Ribble Valley Borough Council  
Council Offices  
Church Walk,  
Clitheroe  
Lancashire  
BB7 2RA

Phone: 0300 123 6780  
Email: [Kathryn.Walsh@lancashire.gov.uk](mailto:Kathryn.Walsh@lancashire.gov.uk)  
Your ref: 3/2024/0498  
Our ref: 3/2024/0498/HDC/KW  
Date: 16 December 2024

**Location:** Penrhyn Whalley Road Barrow BB7 9BA  
**Proposal:** Proposed roof lift and installation of dormers, extensions to front, rear and sides to create five-bedroom, two-storey dwelling, double garage and patio area. Installation of solar panels.  
**Grid Ref:** 373925 438560

The Local Highway Authority (LHA) are in receipt of an application for the proposed roof lift and installation of dormers, extensions to front, rear and sides to create five-bedroom, two-storey dwelling, double garage and patio area. Installation of solar panels at Penrhyn Whalley Road Barrow BB7 9BA

PROPOSED GROUND FLOOR PLAN
1:100

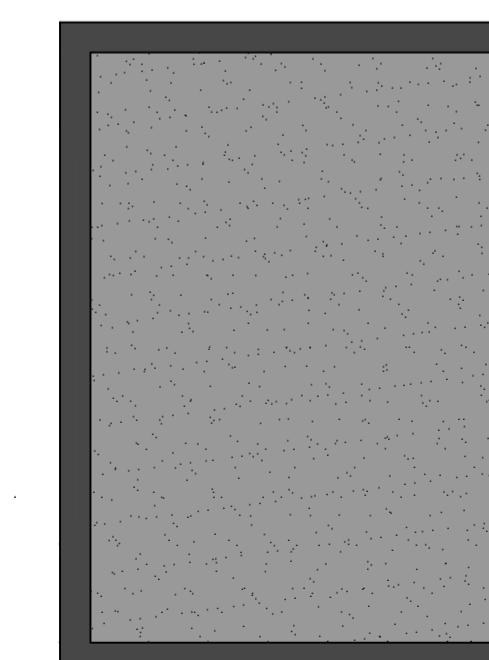
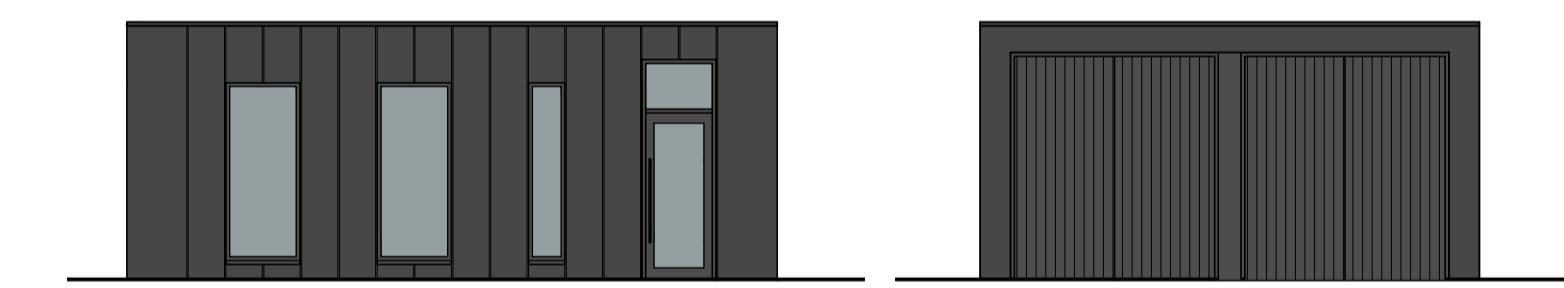
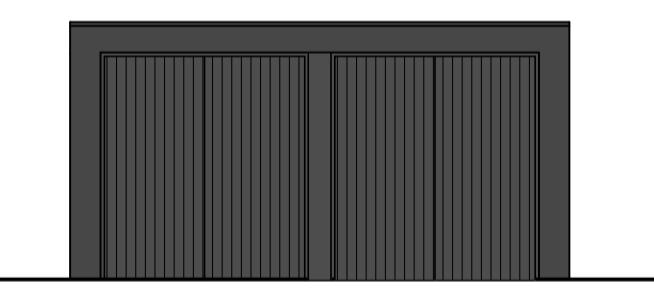
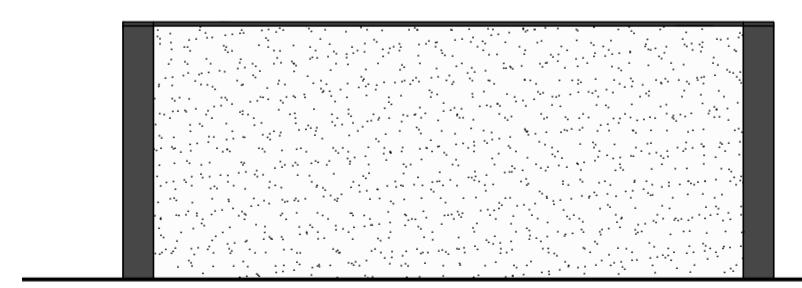
The LHA also reviewed drawing LU313-P04 titled Garage plans and noted that the proposed garage meets the LHA recommended minimum internal dimensions for a single garage size which is 6m in length and 3m wide.

PROPOSED SITE PLAN
1:200

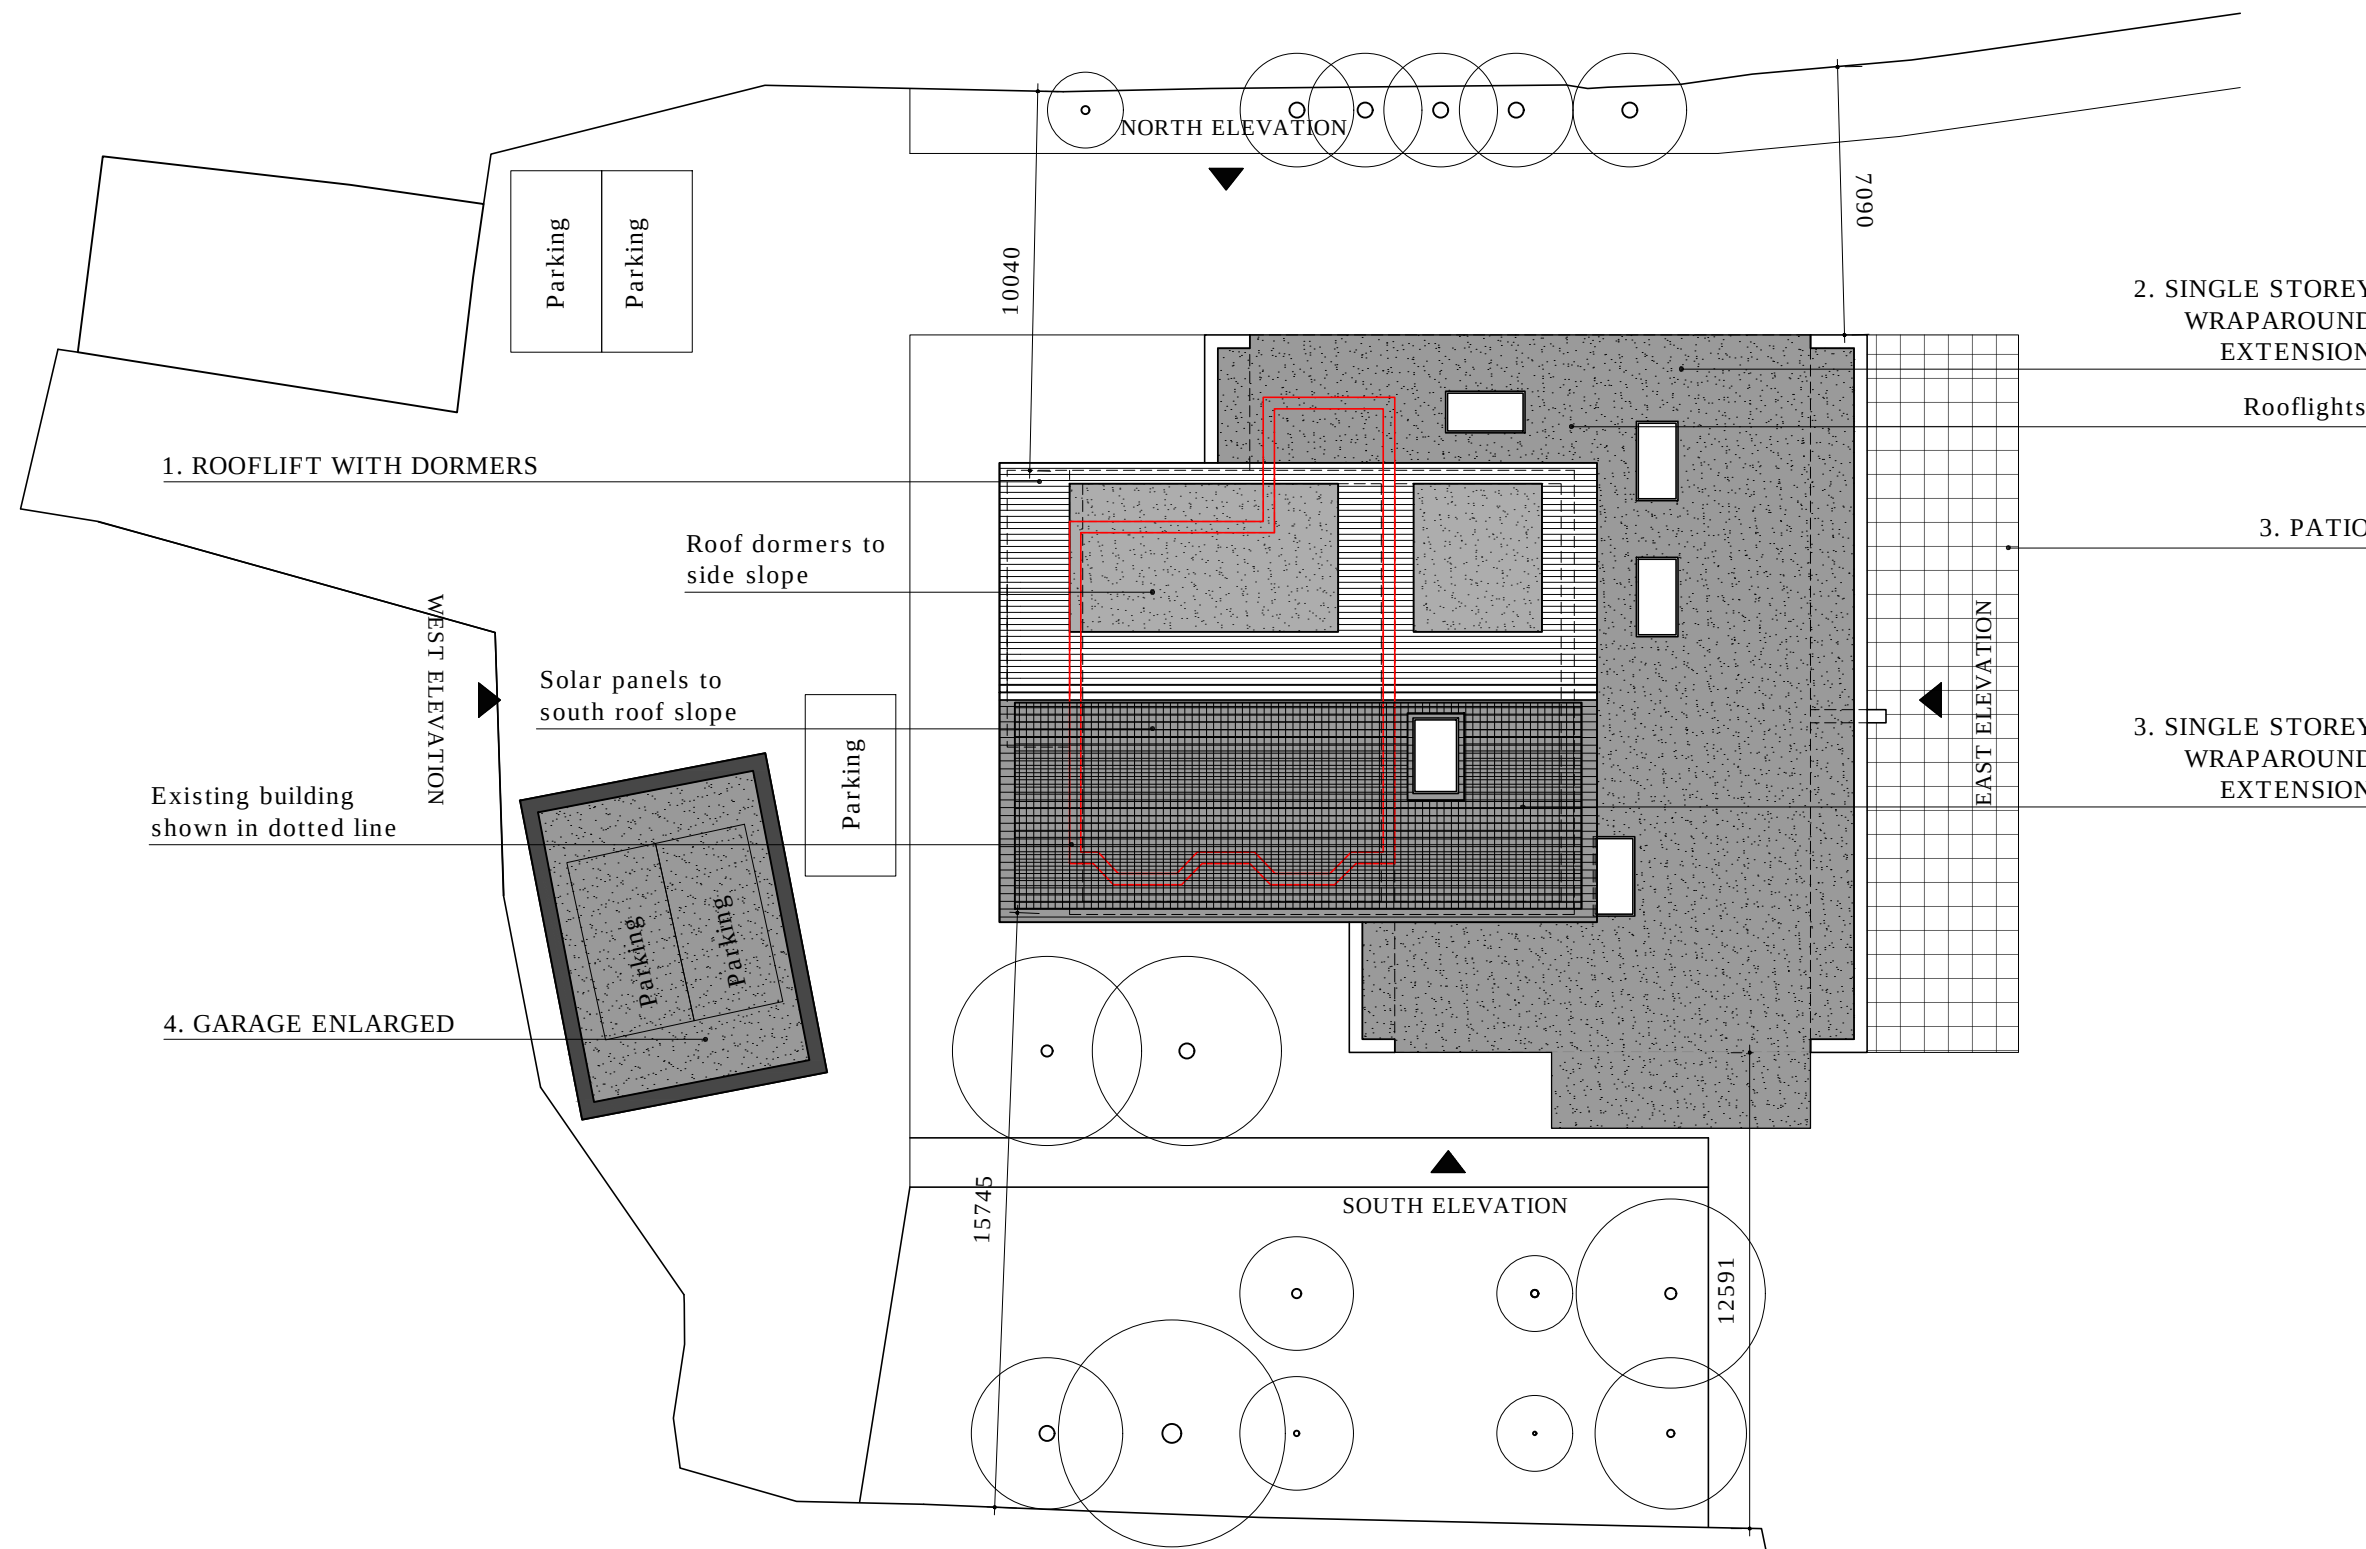
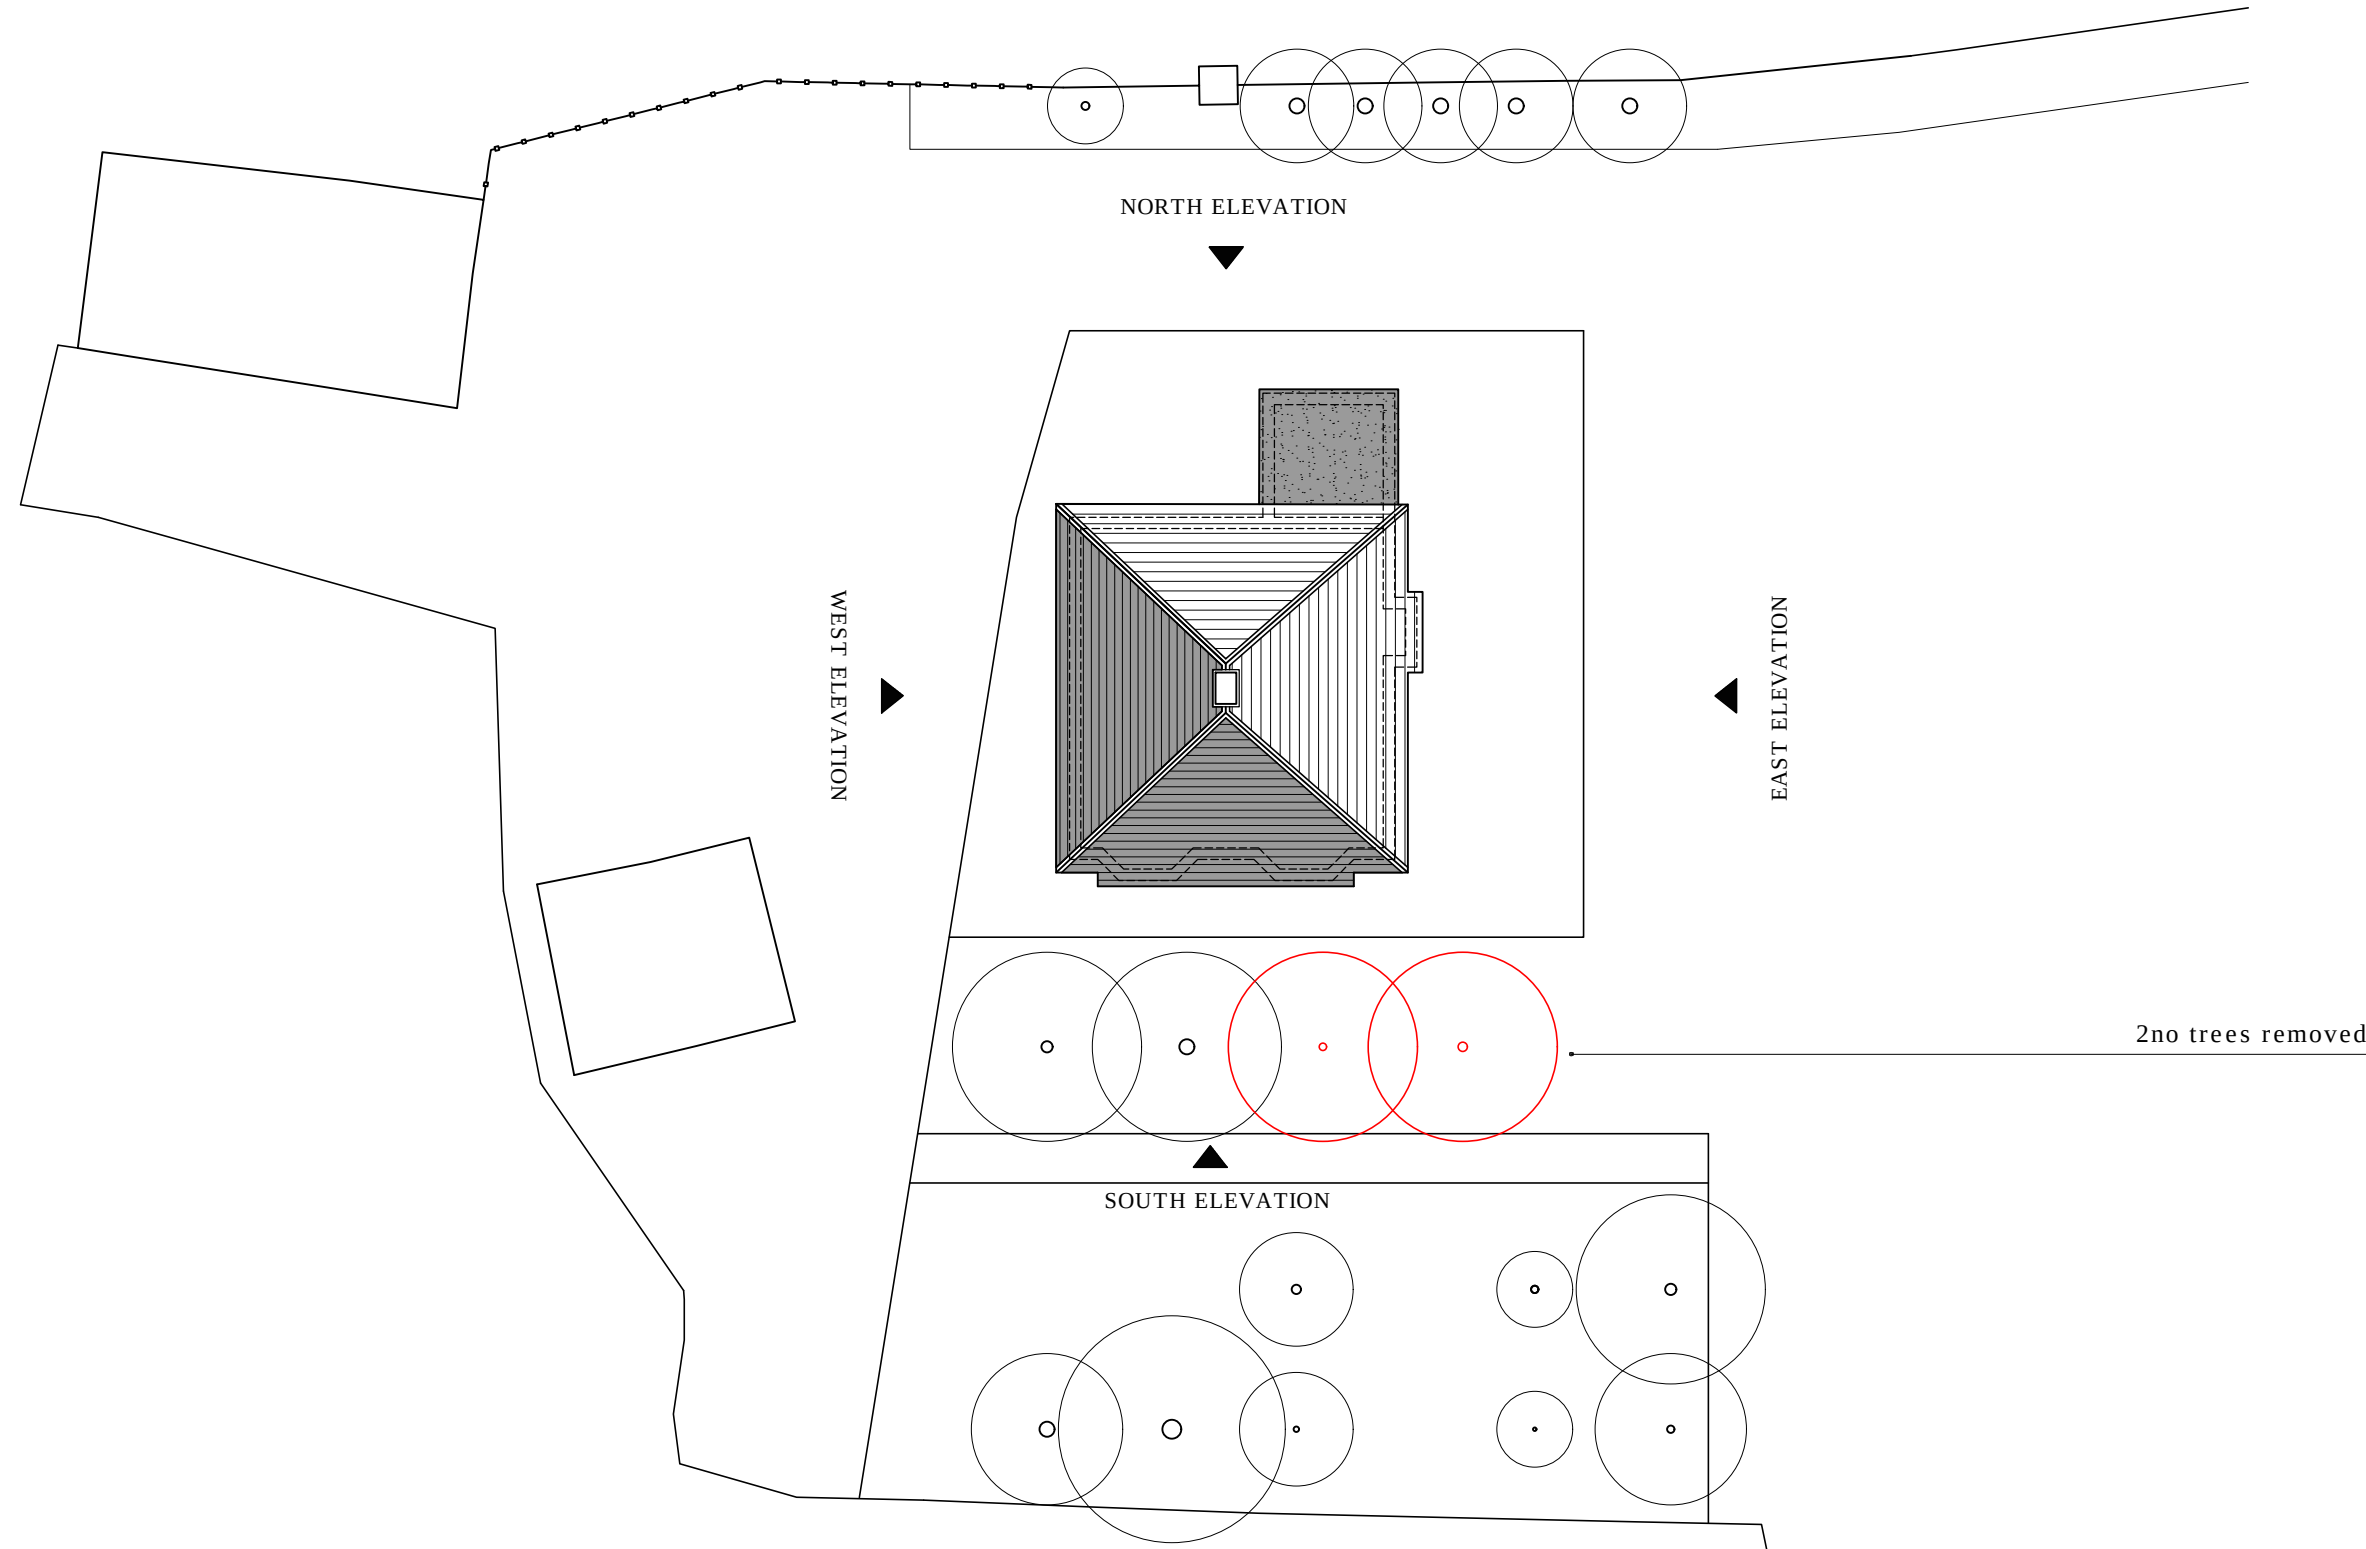
The LHA has reviewed the proposed site plan, drawing LU313-P01, are aware that the dwelling will continue to be accessed from a private track off Whalley Road which is a C classified road, the C549, and subject to a 30mph speed limit.

The LHA has reviewed proposed site plan, drawing LU313-P01 and are aware that the dwelling complies with the LHAs parking standards as defined in the Joint Lancashire Structure Plan. There is also room to turn within the site and leave in a forward gear.
